09033

6 July 2010

Re: Part 3A Application: 7-9 Gibbons Street, Redfern

DRAWING:
BASEMENT &
GROUND
FLOOR PLANS
DRAWING No.
DA - 1102
ISSUE
5414
C

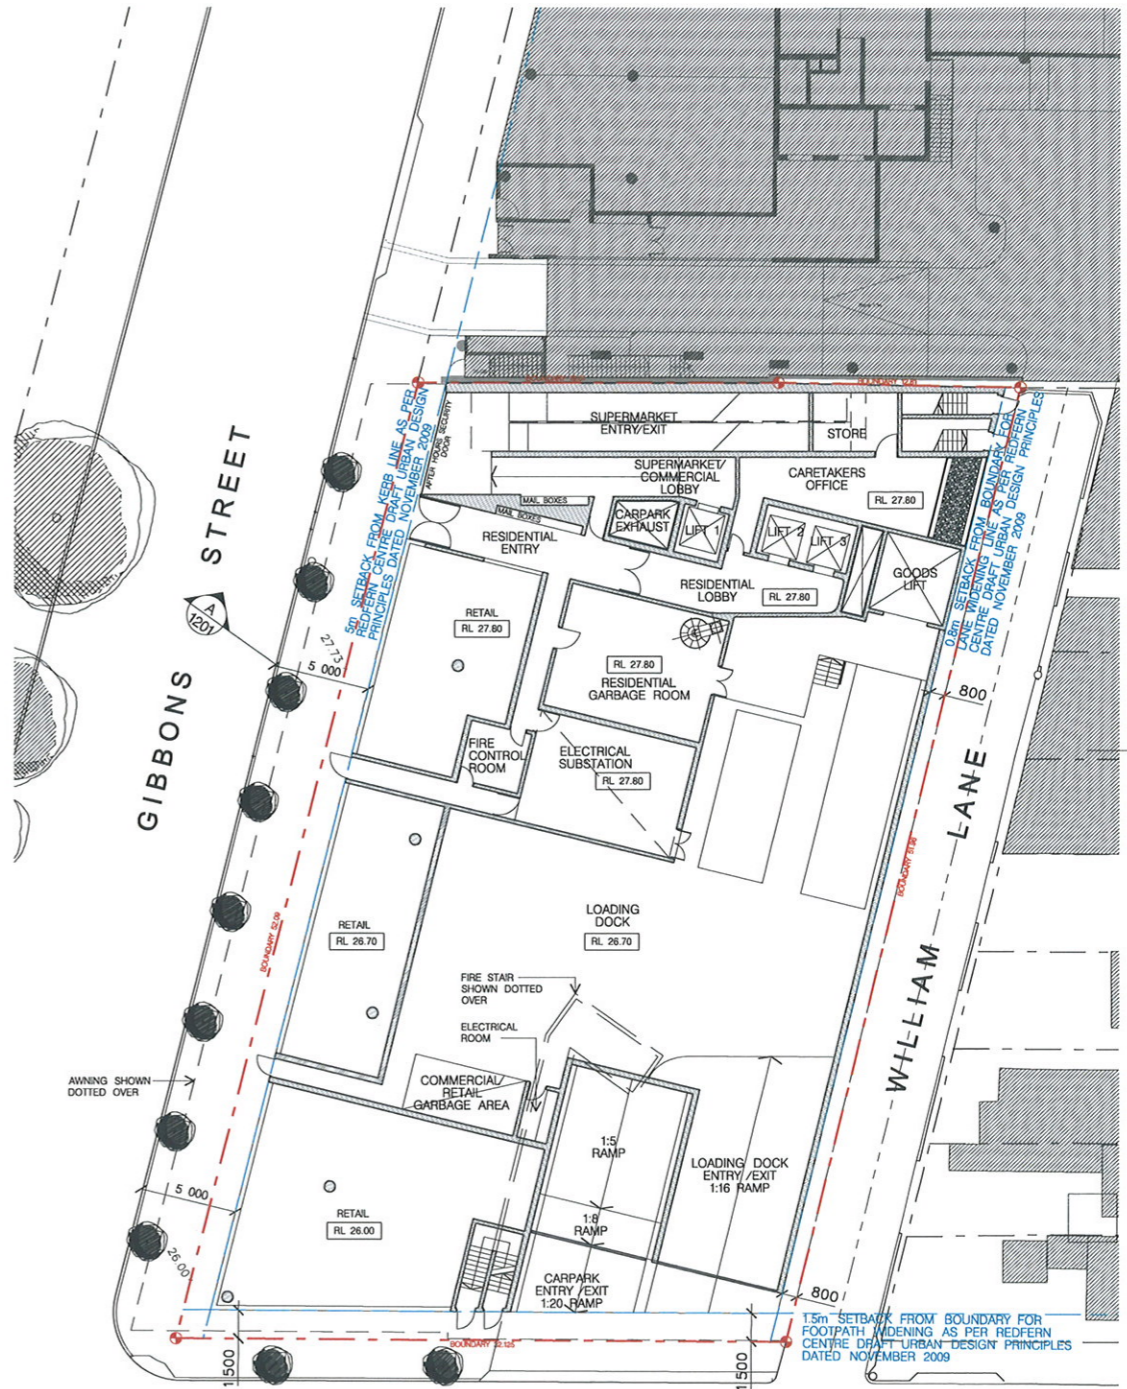
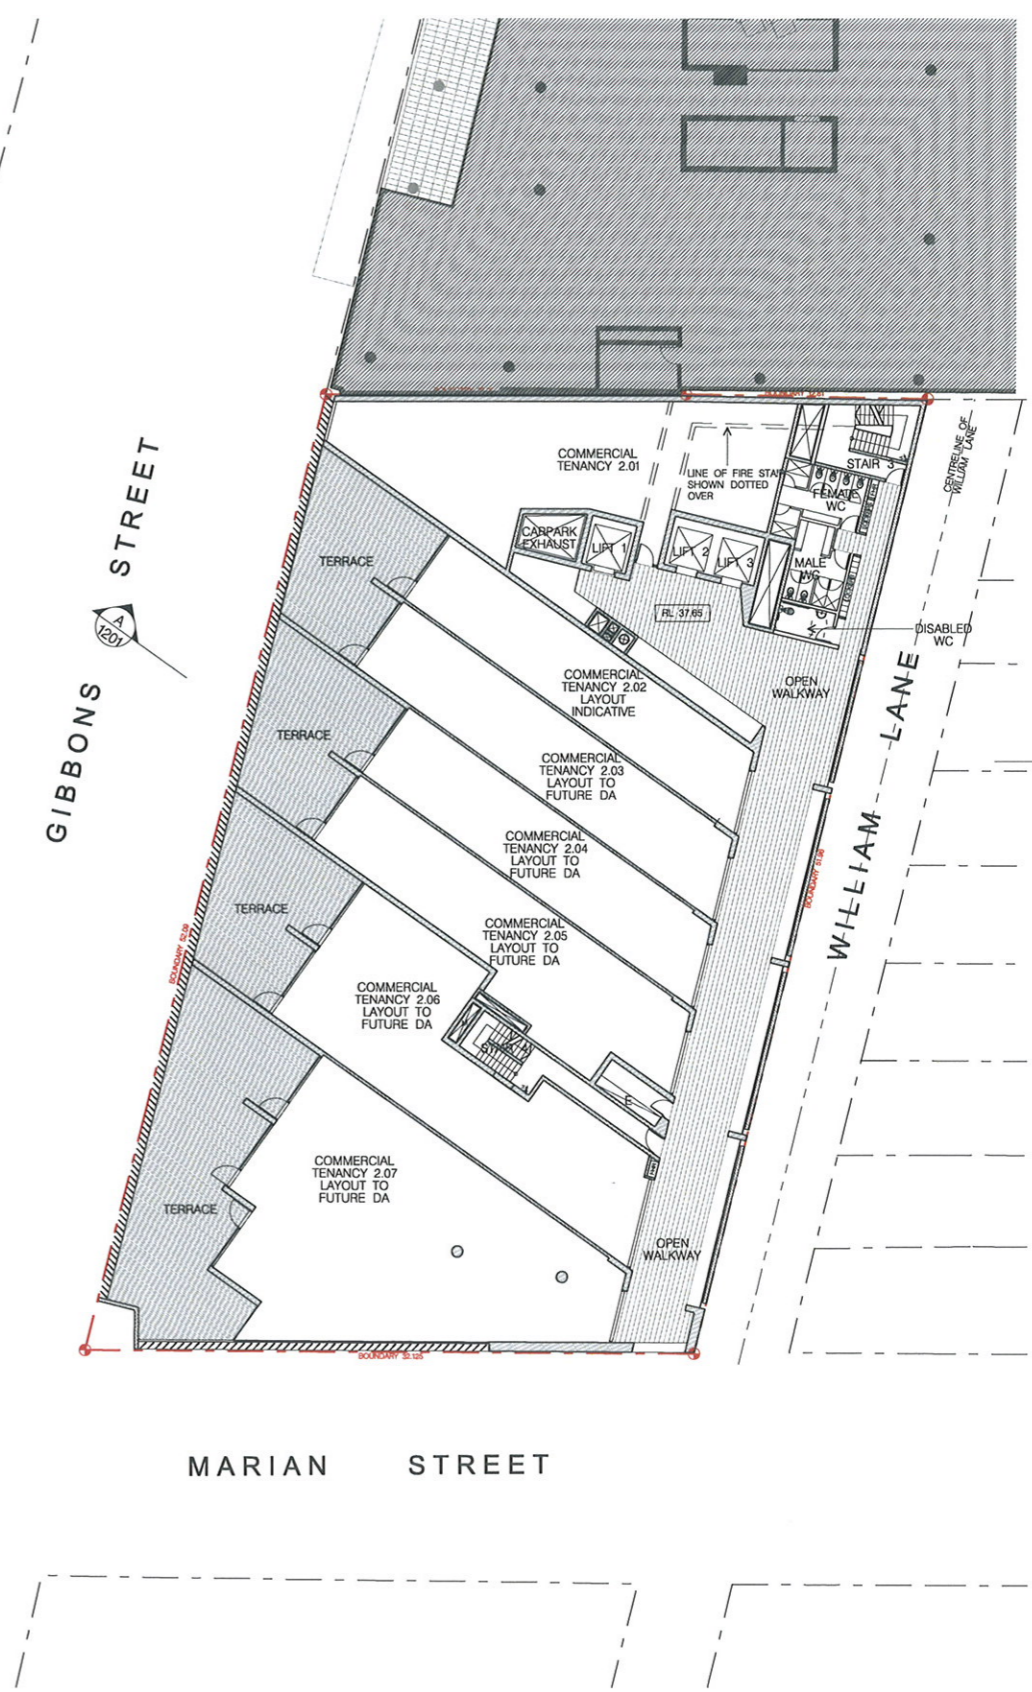
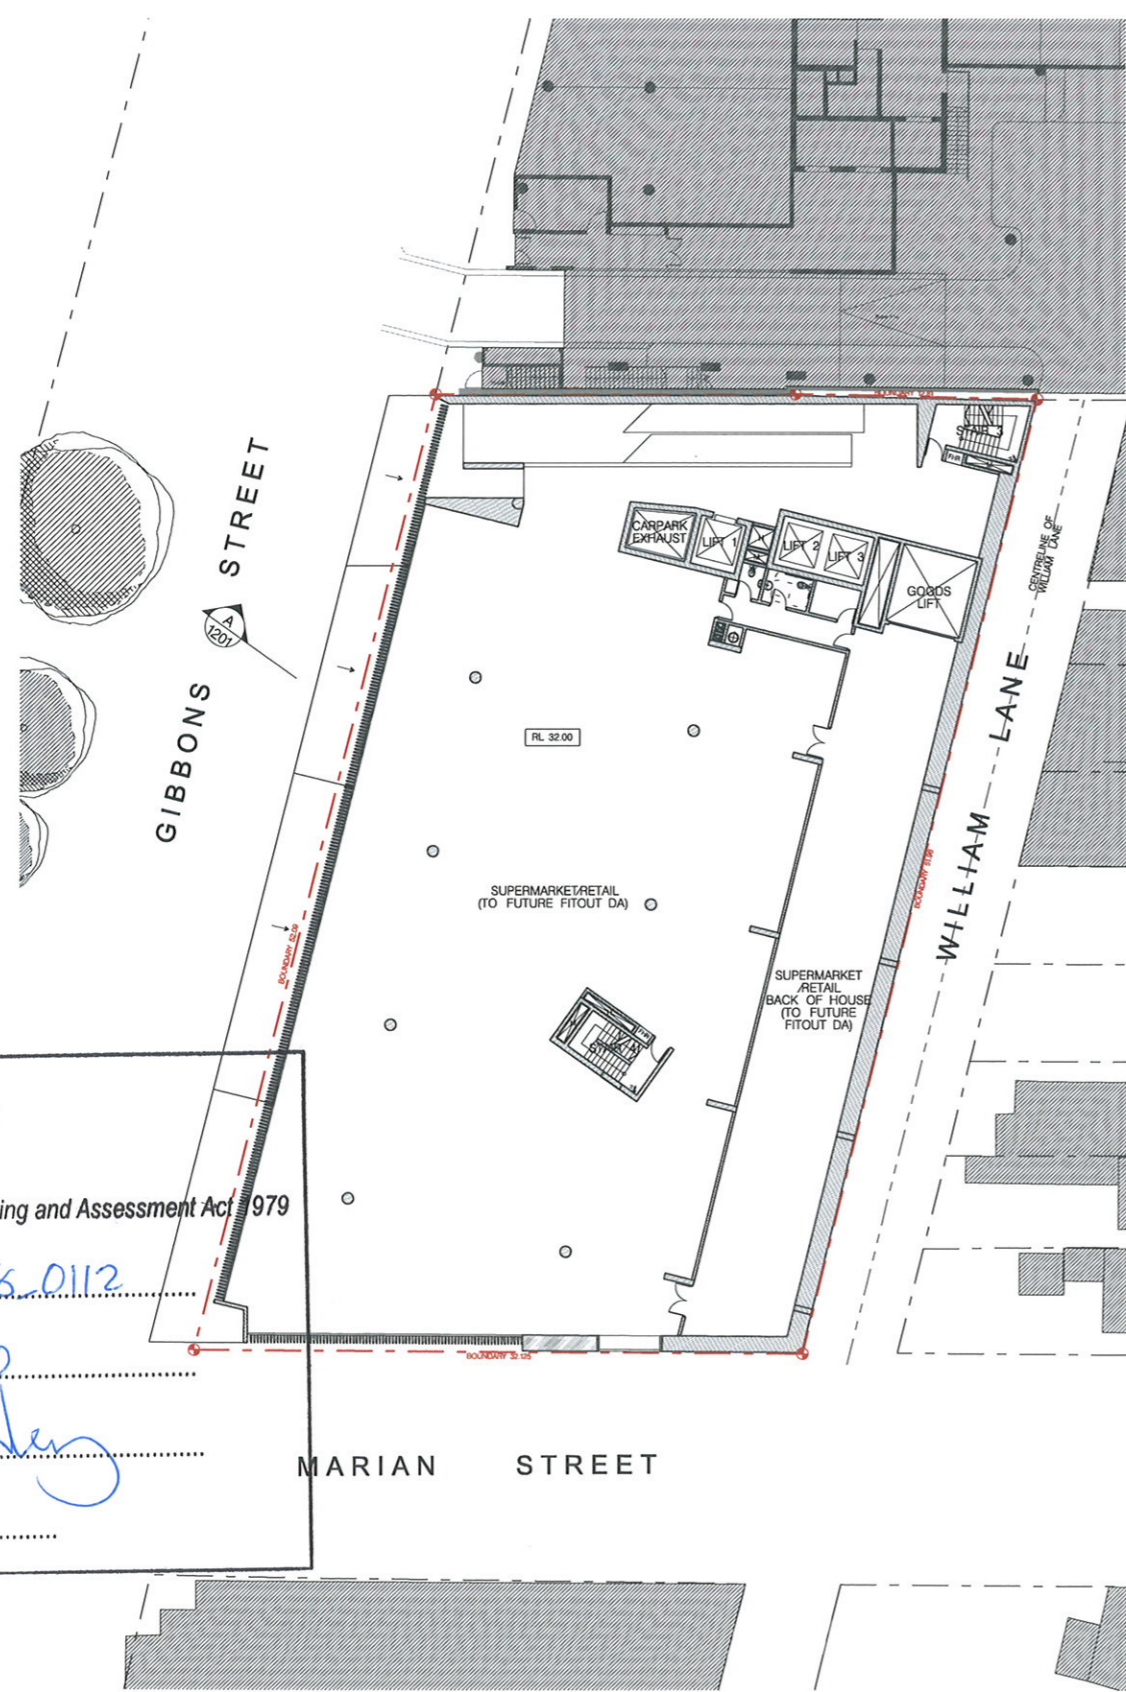
The 15m driveway width is an unavoidable outcome of the site constraints. The opportunity to provide a refuge is accepted in principle and this could be conditioned. We note however that this would need to be mountable to enable trucks to access the site.

We refer to the amended plans provided on 1 July 2010 and advise that we have reviewed these plans to establish whether the loading dock can be satisfactorily accessed by a 12.5m HRV, with both entry and exit occurring in a forward direction. We confirm that this is the case and satisfactory manoeuvrability is demonstrated by the swept path analysis provided in **attachment a**.
